REQUEST

Current Zoning: N1-A (neighborhood 1-A)
Proposed Zoning: N2-A (CD) (neighborhood 2-A, conditional)

Approximately 17.48 acres located along the south side of Johnston Oehler Road, east of Prosperity Ridge Road.

The petition proposes a residential community of up to 115 multi-family attached dwelling units.

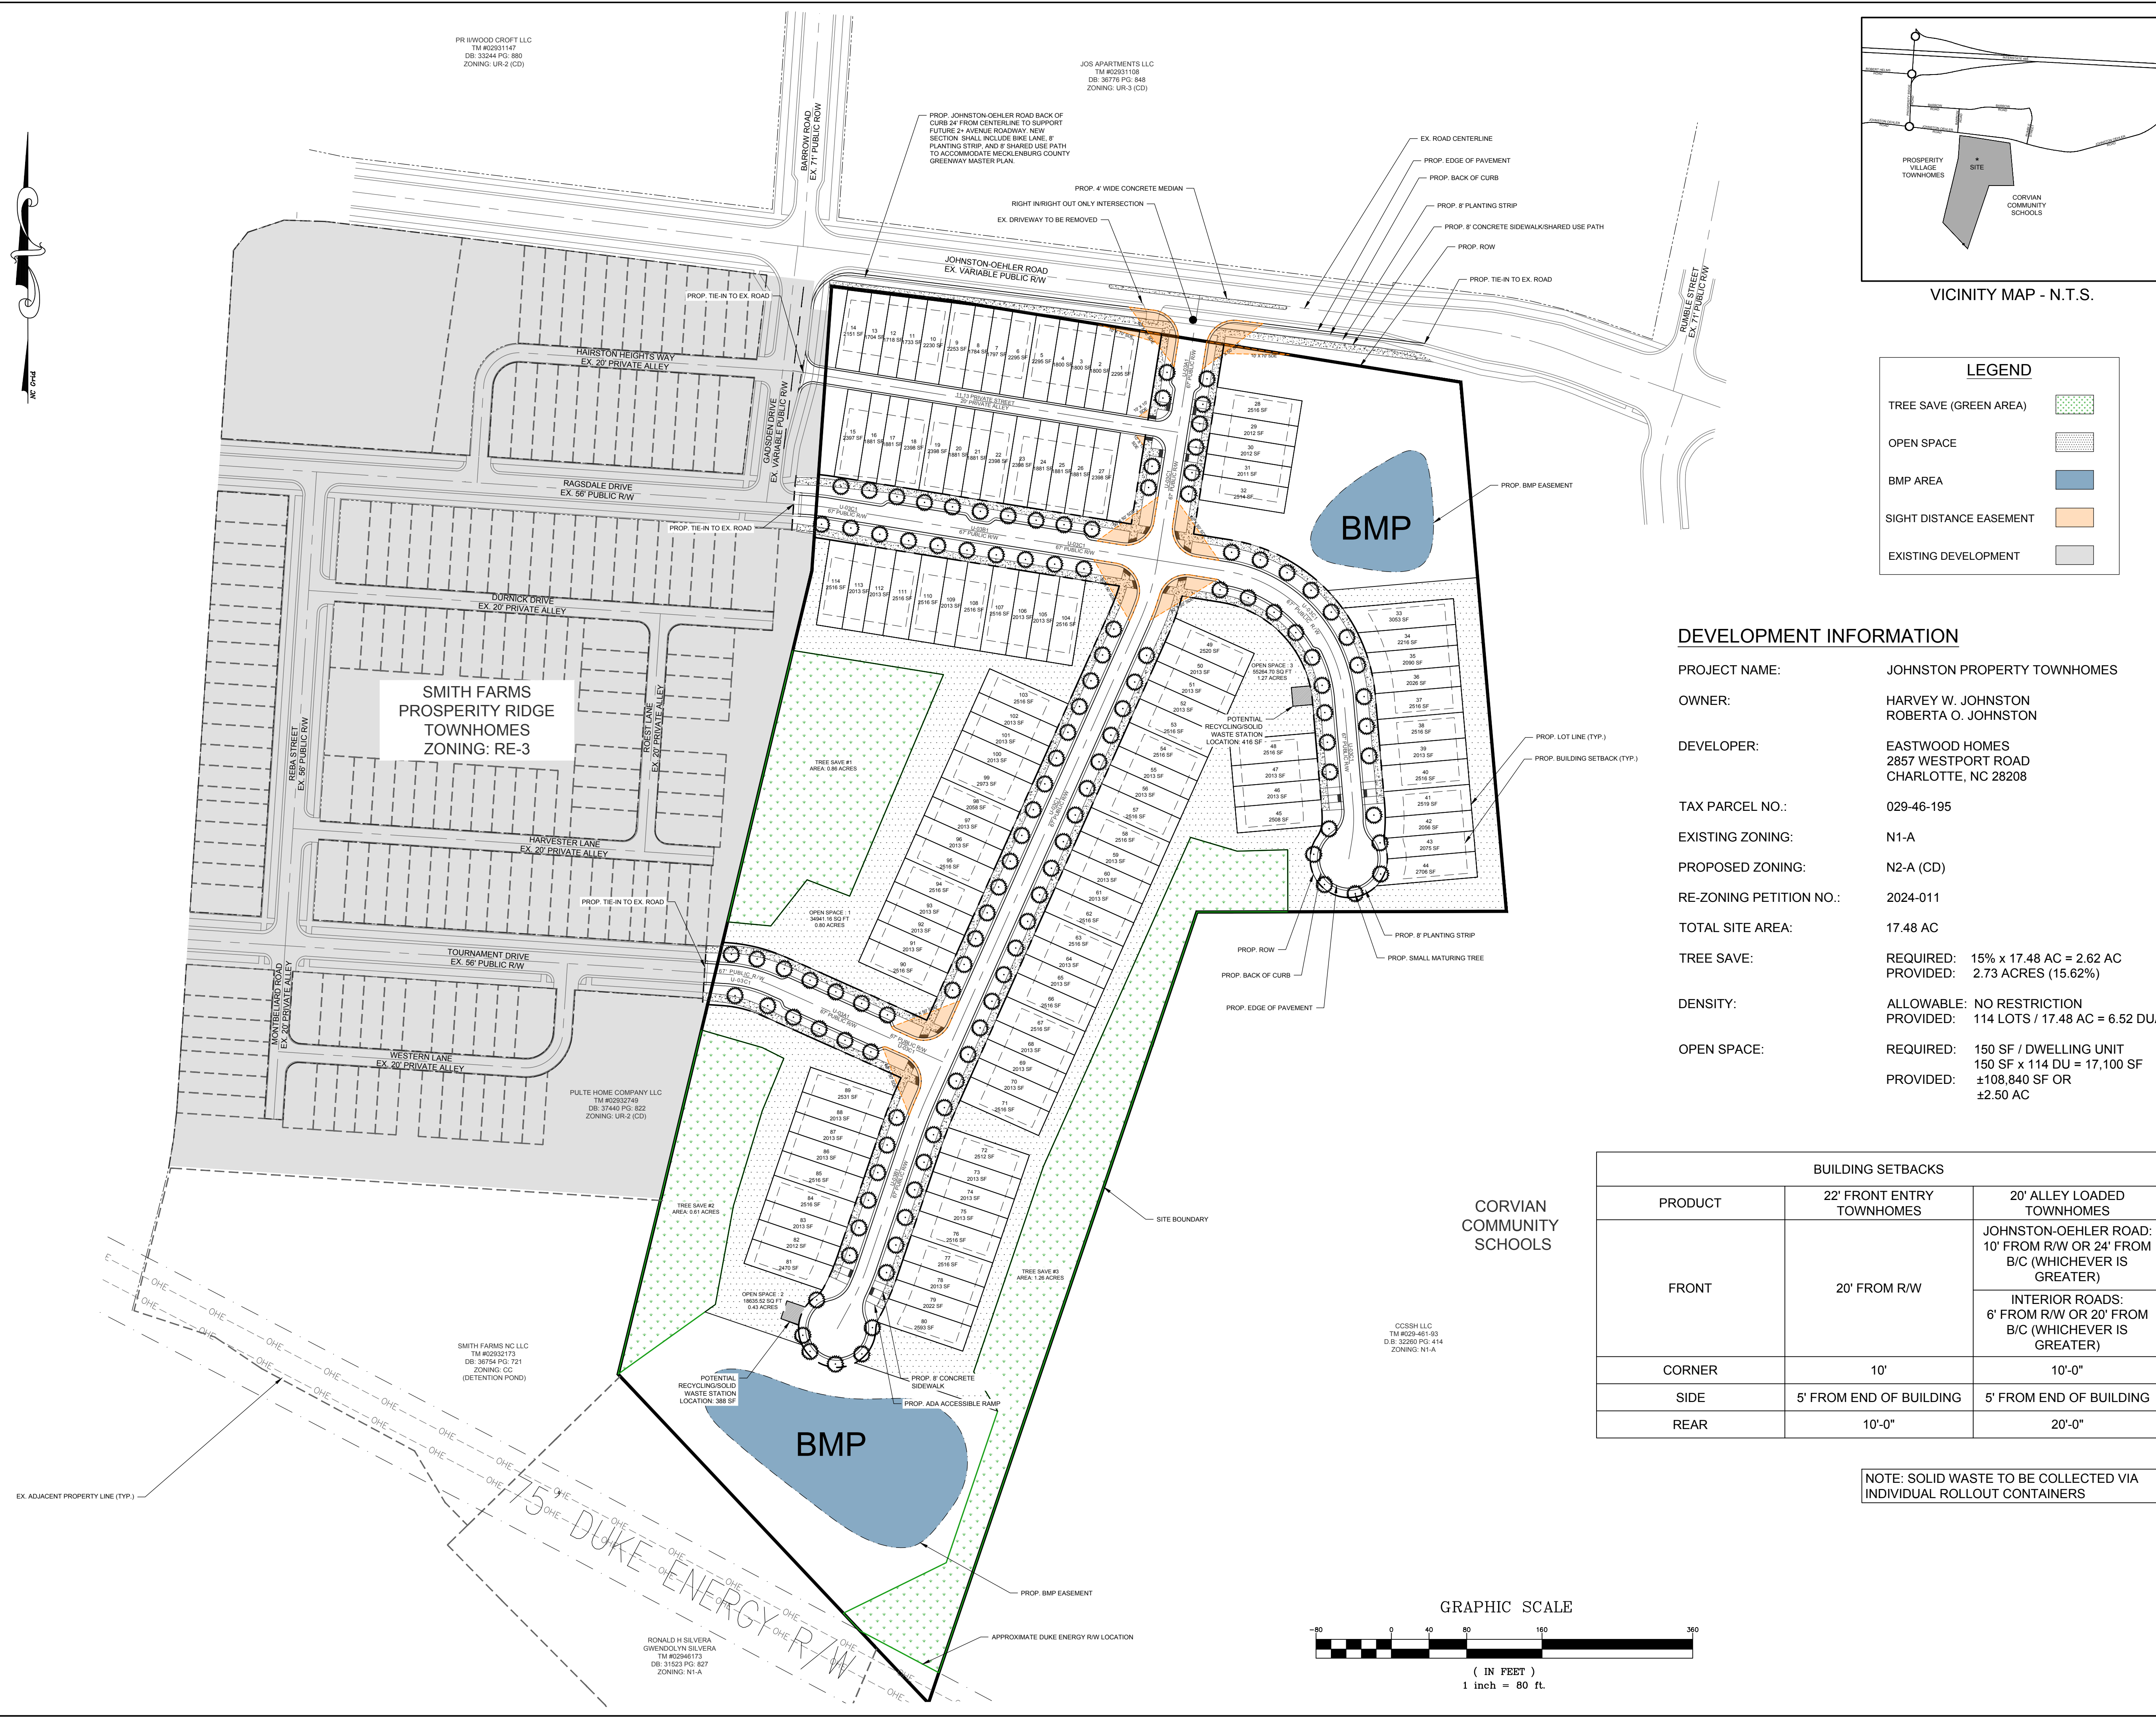
1. Add Comprehensive Transportation Review (CTR) table with offsite commitments to the site plan.
